**Traffic and Transport**

- 1.1 LCC in its statutory capacity as Local Highway Authority (LHA) hereby referred to as LCC LHA has reviewed the submissions supporting the DCO application against relevant national and local policies, including the NPPF, NPSNN, and the LHDG<sup>1</sup> and cannot conclude that these policy requirements have been met by the application.

- 1.2 Access to the site is proposed via an A47 link road between B4668 Leicester Road, Hinckley and the M69 J2 with the inclusion of new south facing slip roads.

Written Statement of Oral Case ISH6 [Appendix C – Plan for A47 link road footway/cycleway design]

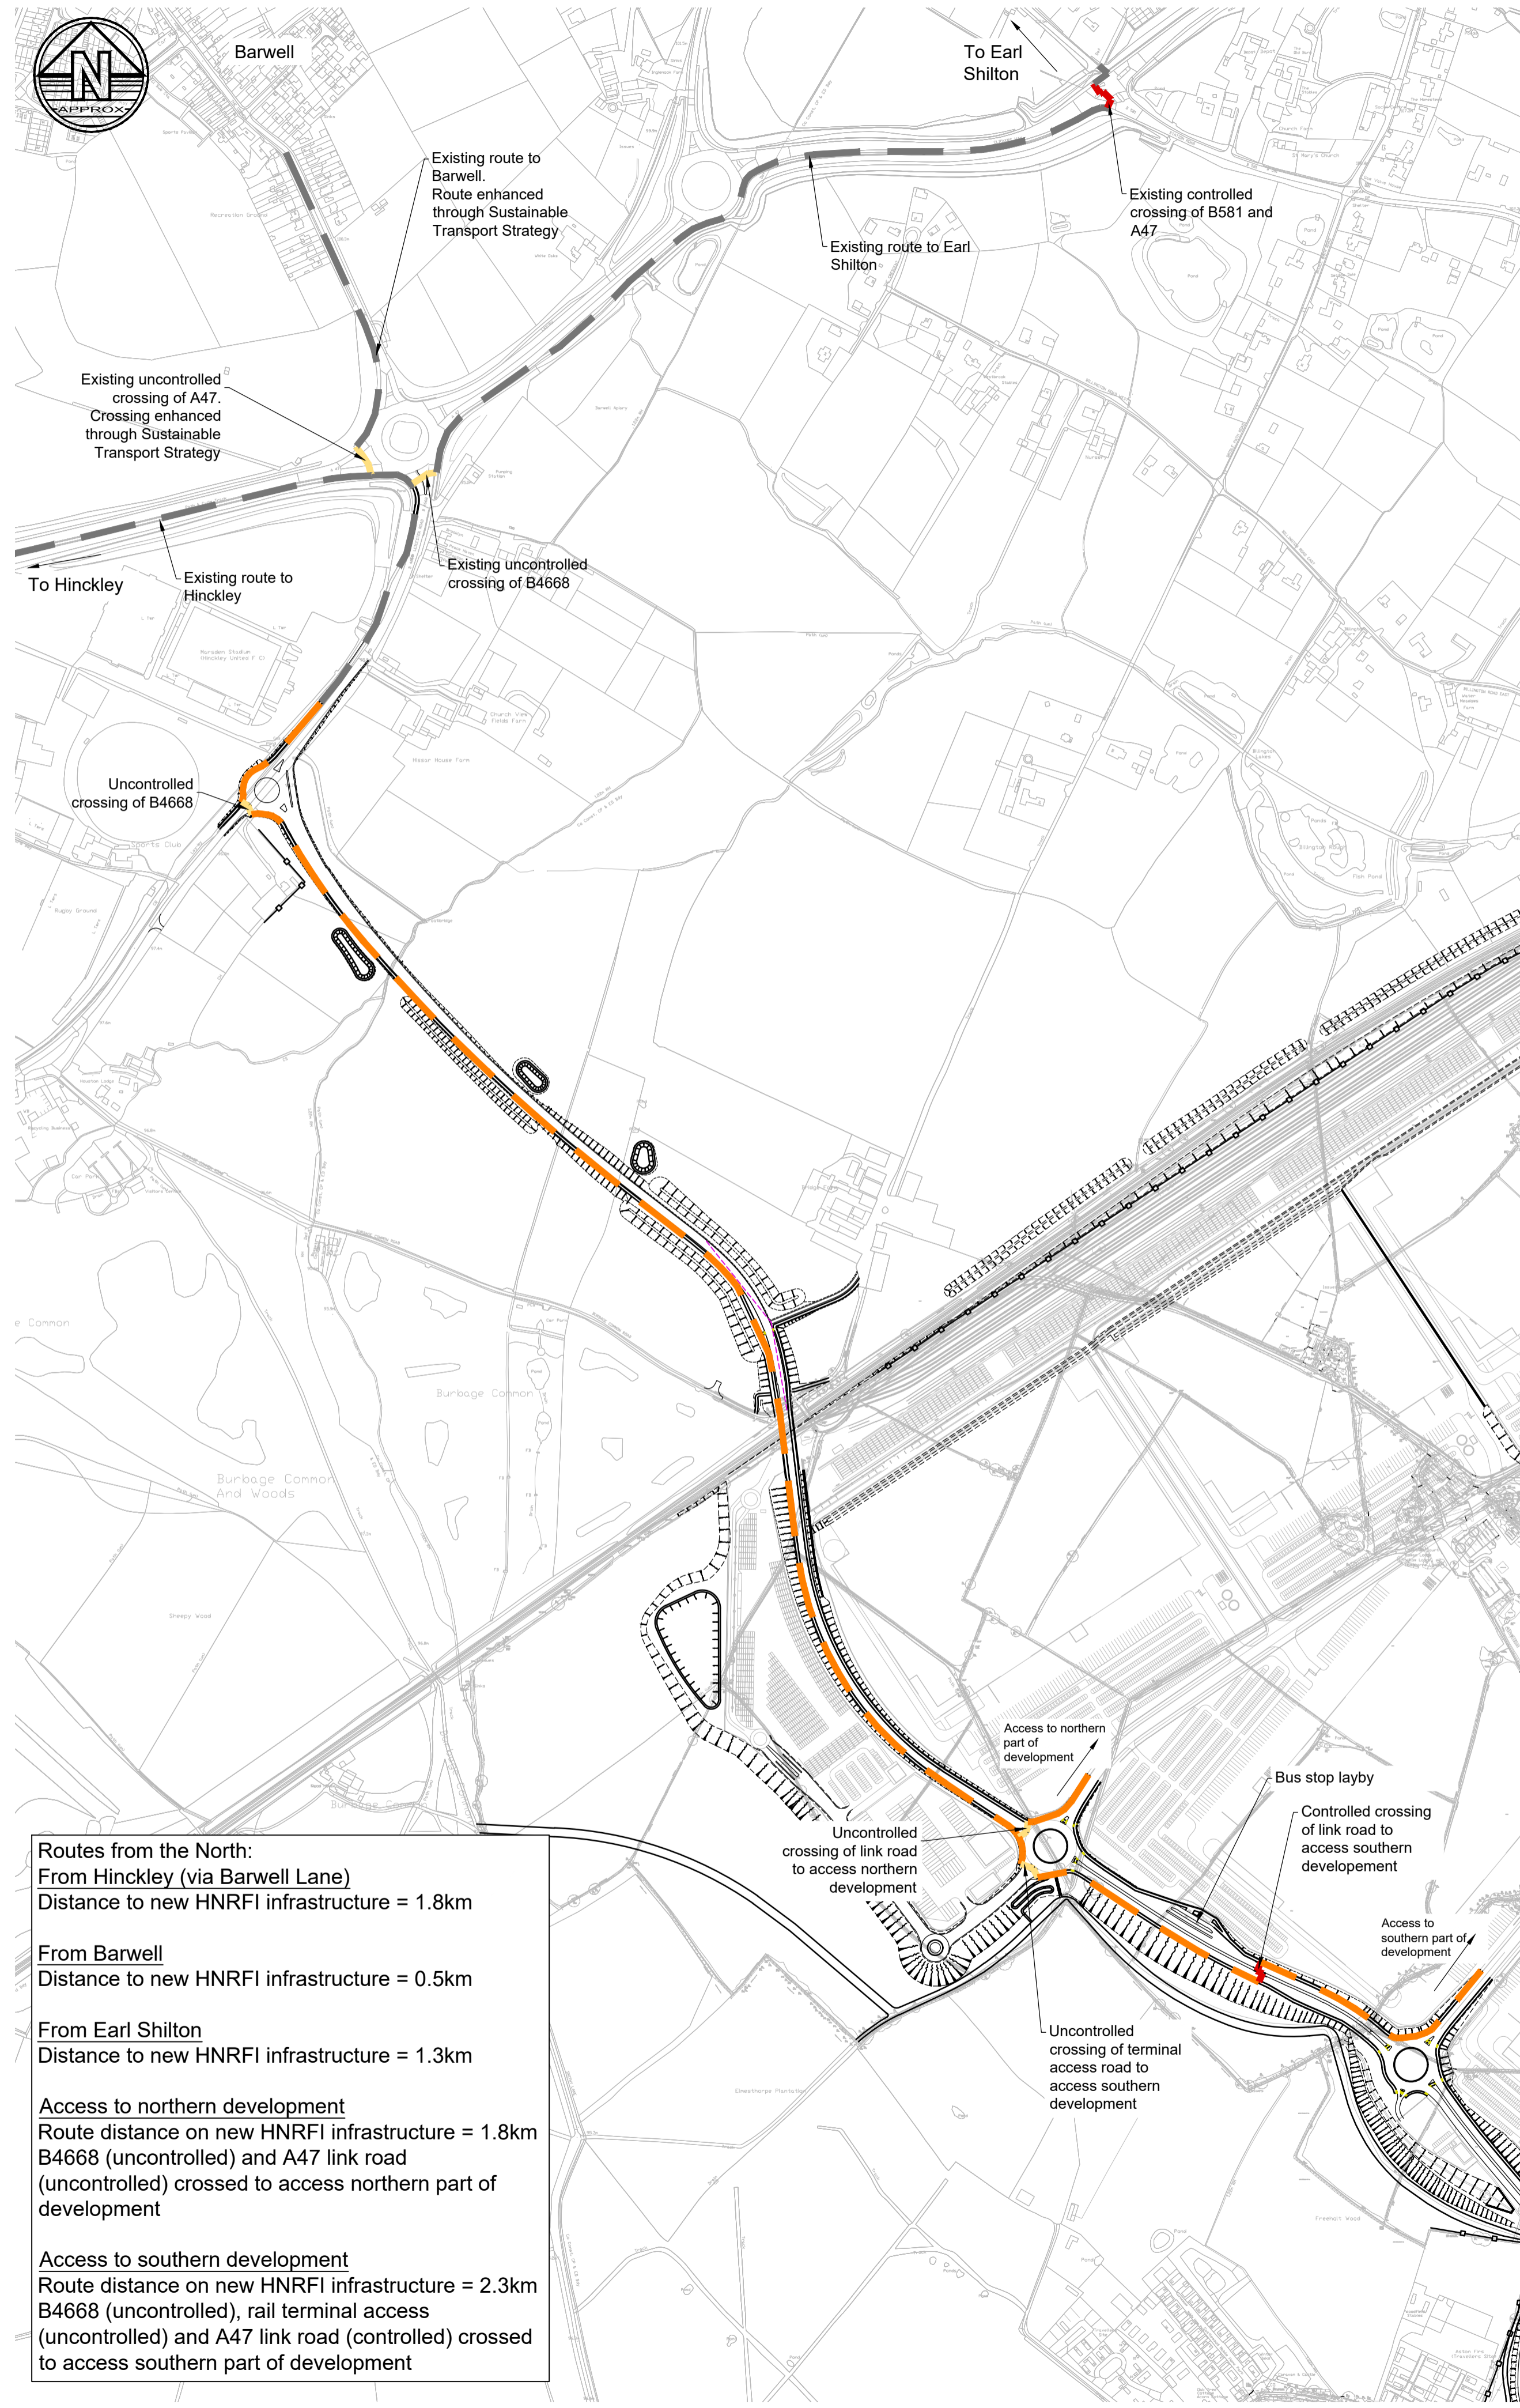
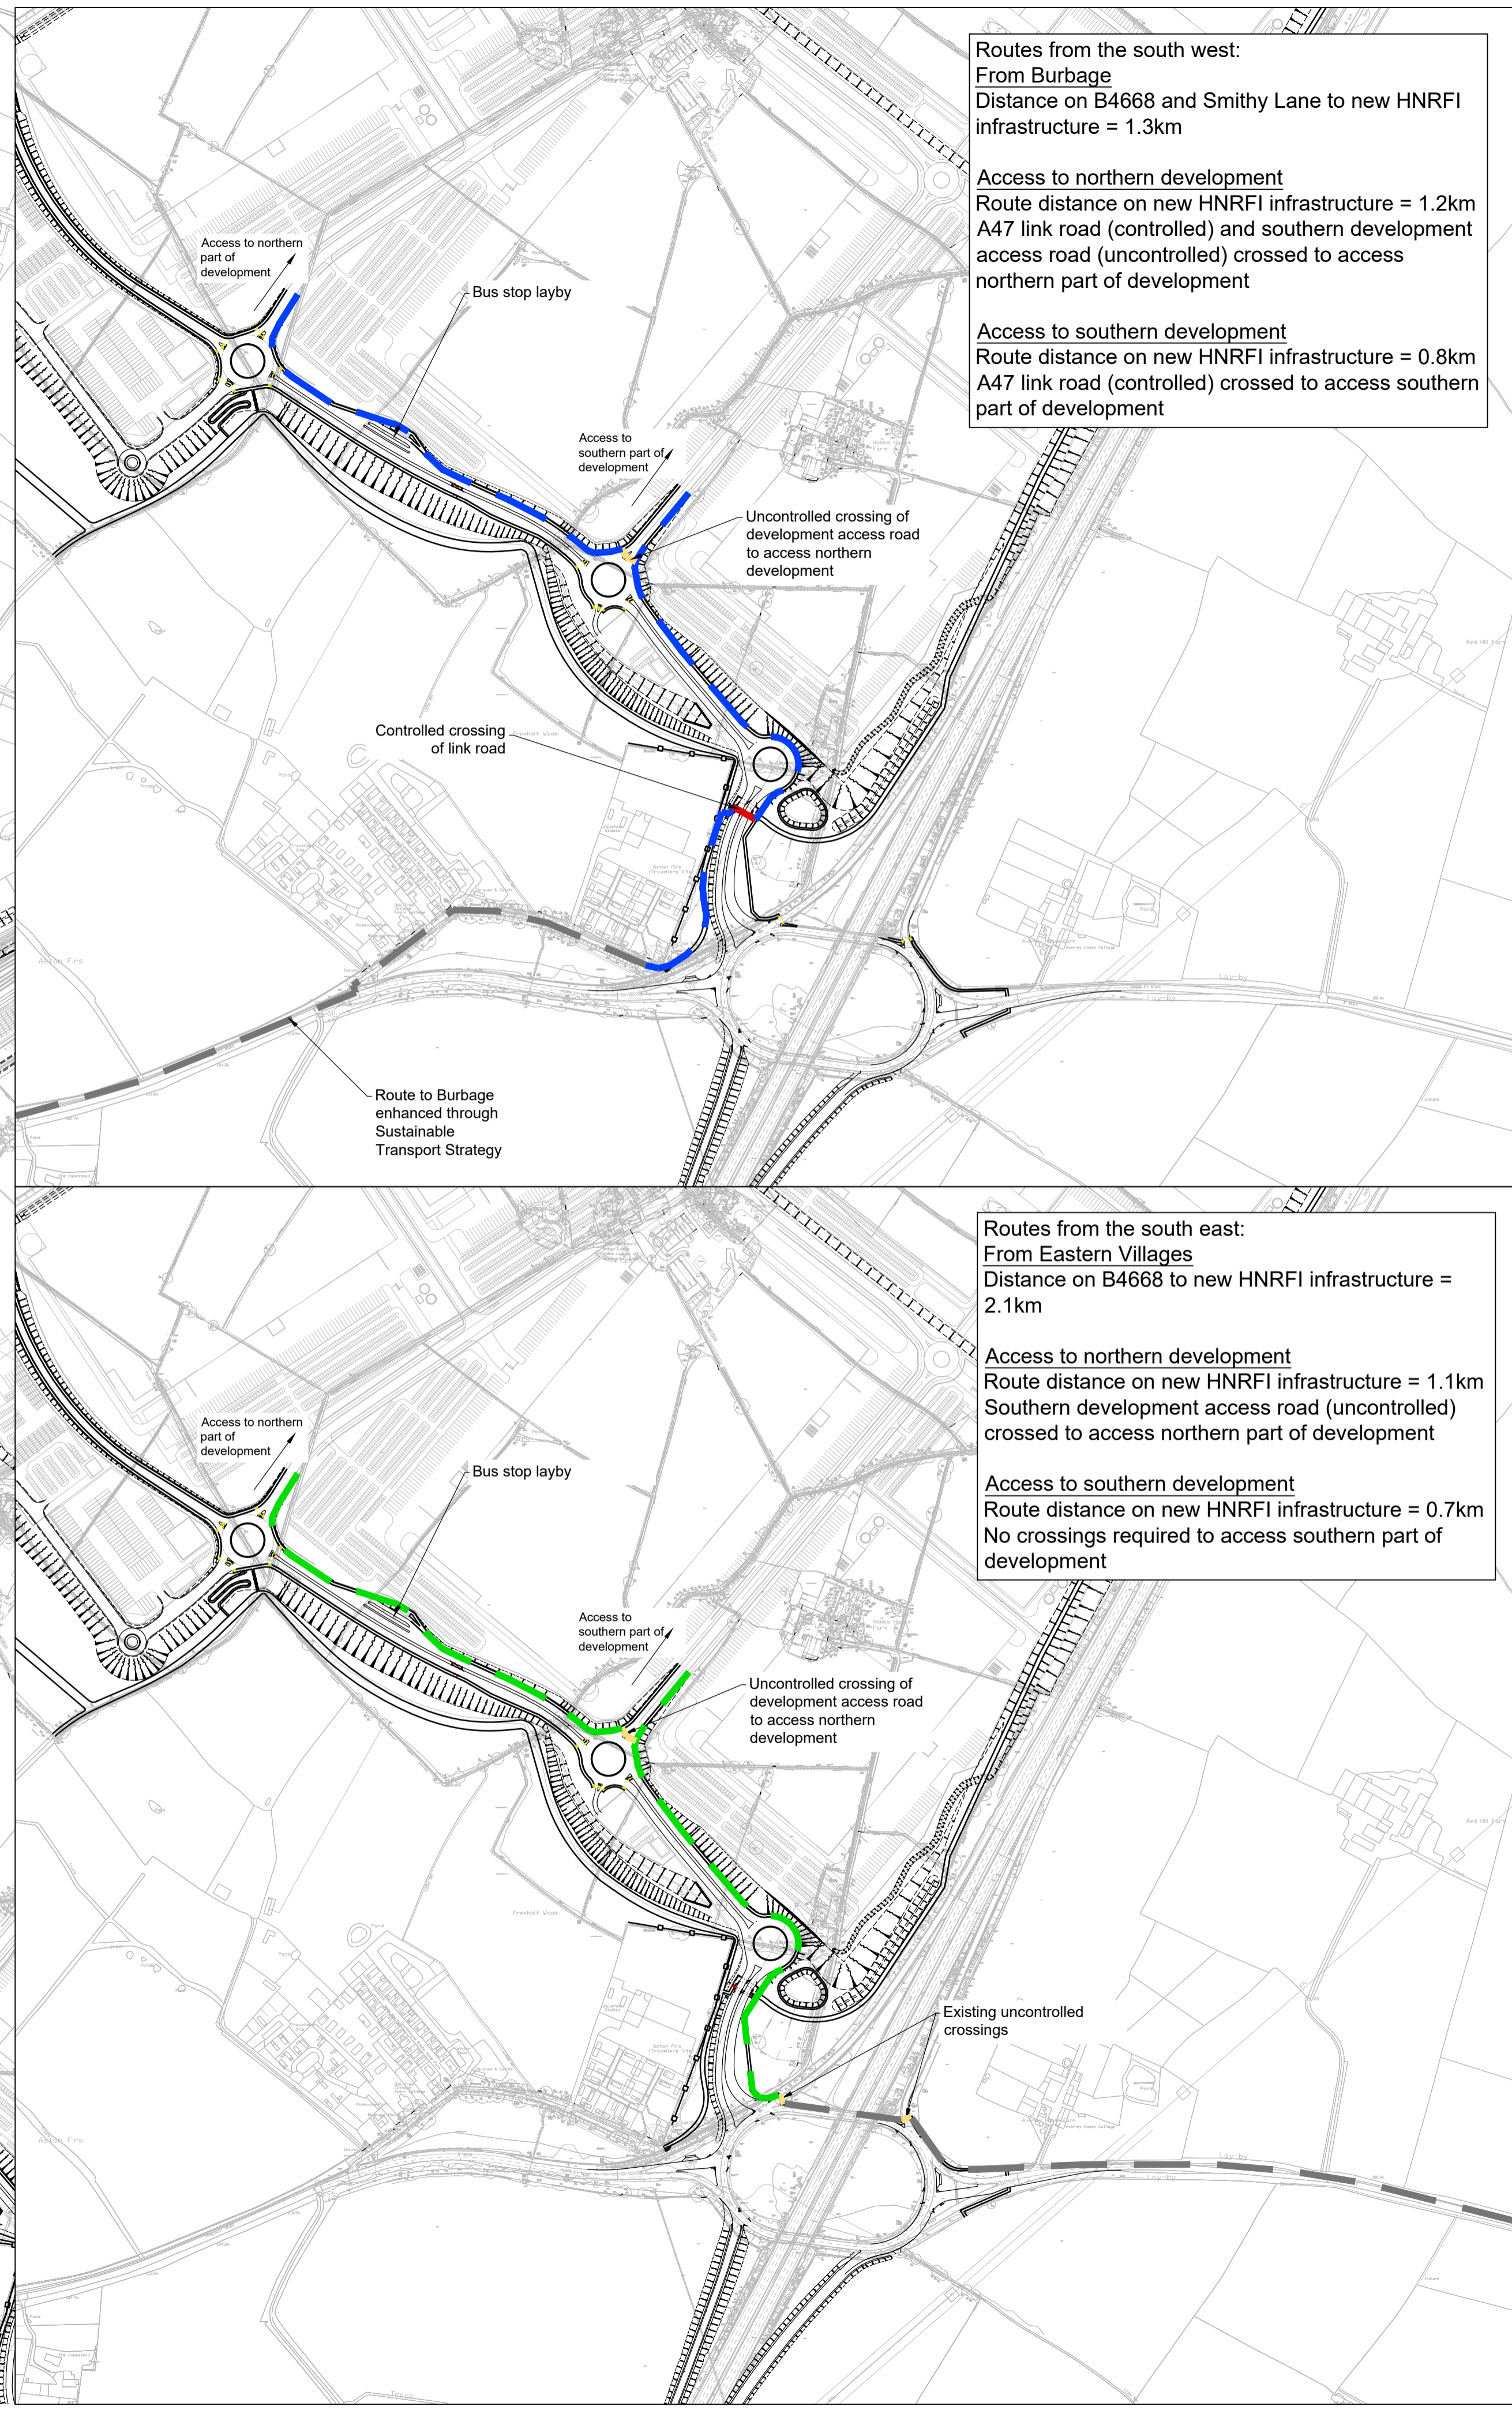
- 1.7 In addition, it would appear that no detailed junction assessments of the roundabouts along the route of the link road have been carried out.
- 1.8 There is no continuous 3m footway/cycleway along the link road.
